Date 16 January 2024
Our Ref 23/01500/FLH

9 West Gardens, Ewell, Surrey

Widening of existing dropped kerb. New front porch, roof extension to accommodate habitable space incorporating rooflights. Alterations to fenestration.

Thank you for your planning application which was received on 25 December 2023. We have checked the application and have found that it is invalid. This means that we cannot currently accept it for registration. The following details must therefore be submitted for the application to be registered:

SITE BOUNDARY

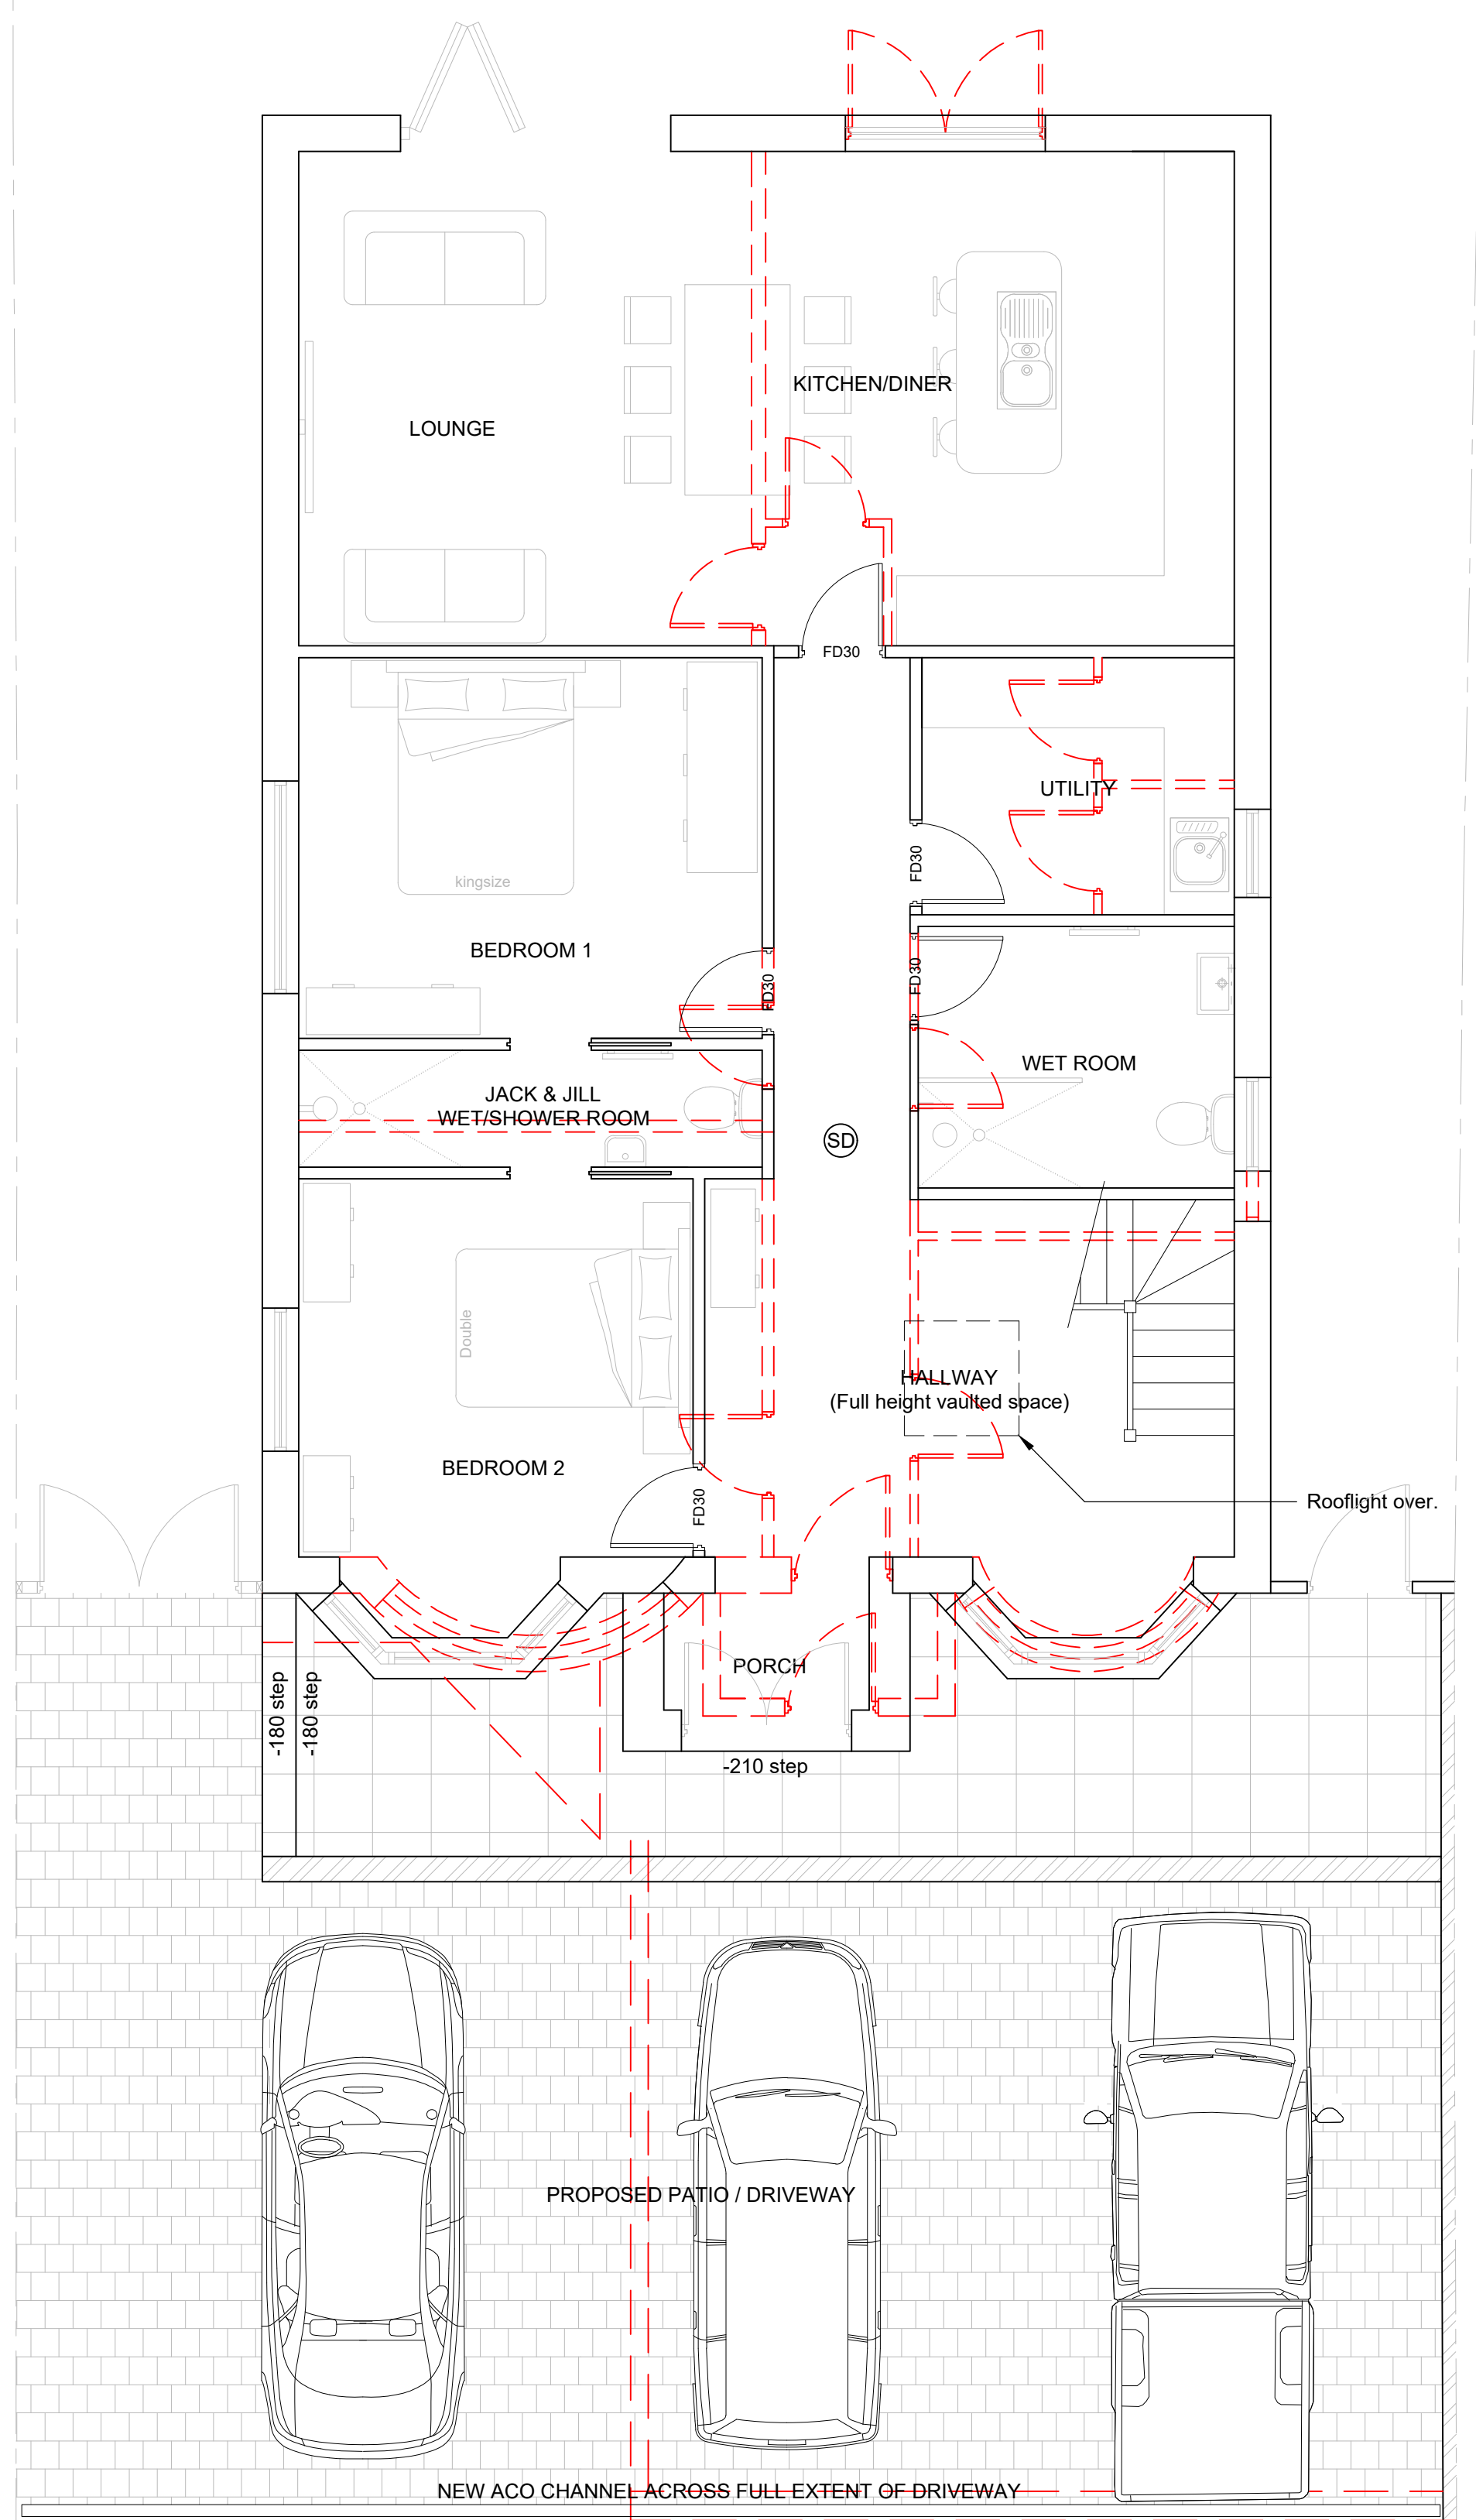
1 Drawing No. 1179-005, Titled Proposed Layouts - The individual drawings on the drawing are detailed as "Existing". Please amend and re-submit to planningsupport@epsom-ewell.gov.uk
